Subject: FW: LU/45/21/DOC - Cornfield Close

In relation to the Verification Report (ref.: GE18103/VR/JAN21, dated January 2021) submitted in relation to the above, whilst the majority of the report seems satisfactory, there are some discrepancies which will please need to be clarified before EH can provide a complete response. For ease, these queries are detailed below:

Plate 3 – Infills Plot 11

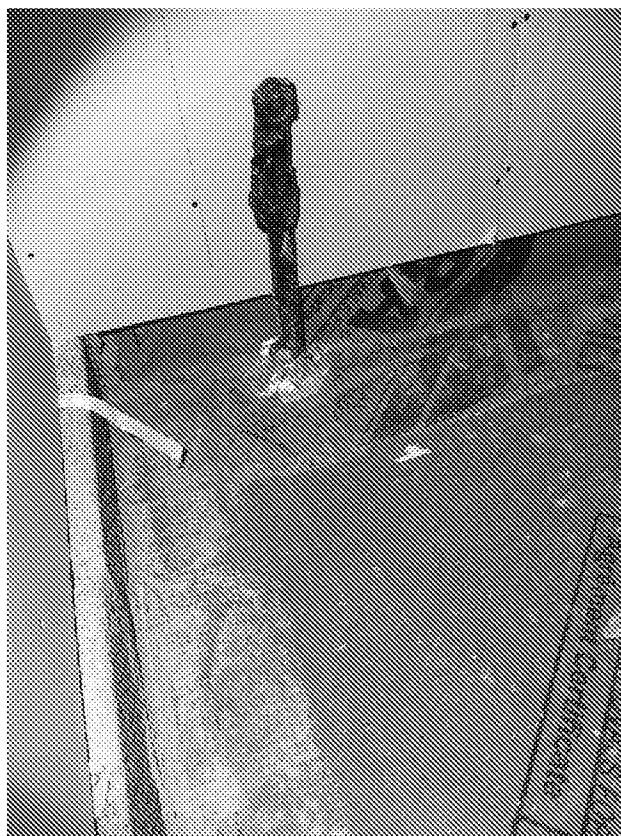
- are the consultants satisfied with the gas protection measures installed? It is understood that Plots 11, 14 and 15 were incomplete at the point of publication, although photographs of the subsequent completion were provided by the applicant's representative.
